CITY OF ALBUQUERQUE

**RE: Replat of Tract 43-C, Unit 2, Atrisco Grant
Drainage Report and Conceptual Grading & Drainage Plan
Engineer's Stamp Date 5-16-2014 (File: L09D043)**

Based upon the information provided in your submittal received 5-16-14, the above referenced plan cannot be approved for Preliminary Plat until the following comments are addressed:

**ROUGH GRADING
PLAN**

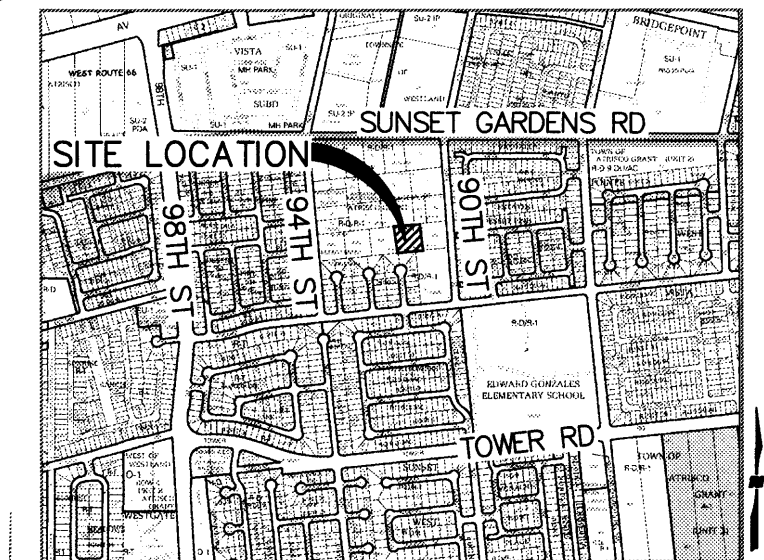
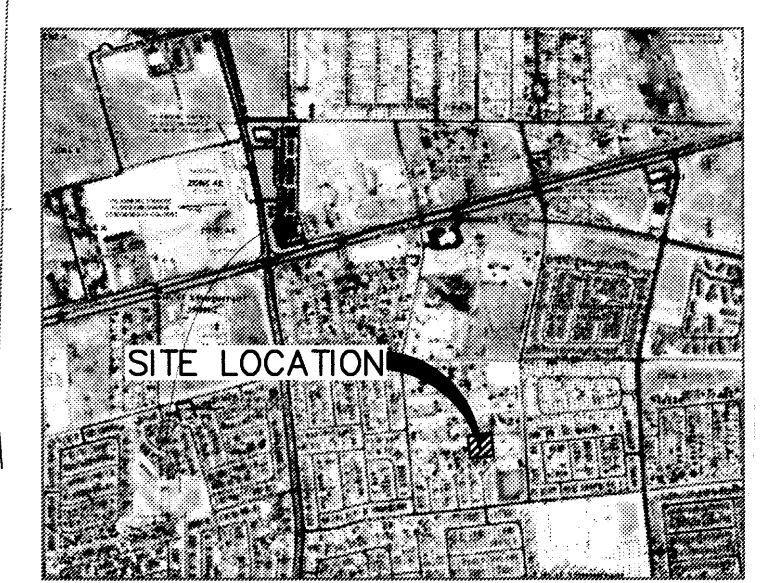
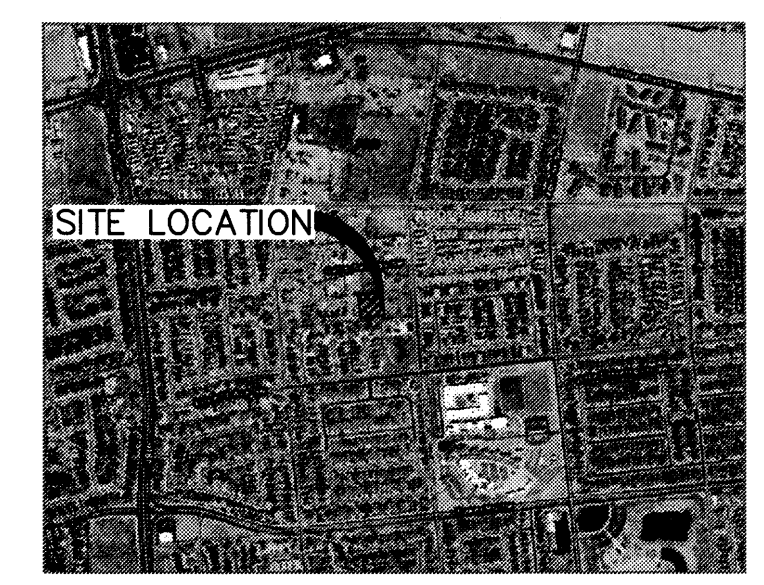
1. The Rough Grading Plan shows a wall along the east edge, but it does not match any of the hatch patterns shown on the legend. Is this a retaining wall? If so, please match hatch intended. The south wall shows an existing wall and also a short length of retaining wall at the east end. Why is there a double wall?

2. The walls shown on the Rough Grading Plan have Bottom of Wall elevations that do not match the grade, neither proposed nor existing. Top of Wall elevations need to be corrected as well.

3. How do offsite flows from the west cannot continue through, given that a wall cuts off that flow? It is unclear how offsite runoff flows through lots. Drainage easement goes only partially thru lots on west, and does not continue all the way through. Grades do not support flow from cul-de-sac to access road.

4. It is not clear where proposed grade lines tie into existing grade lines. Show spot elevations around proposed dwelling units.
5. Show contours beyond south property line.

6. On-site shallow ponding concept should be shown on rough grading plan.
7. Indicate the amount of discharge each lot is allowed and the amount to be ponded.
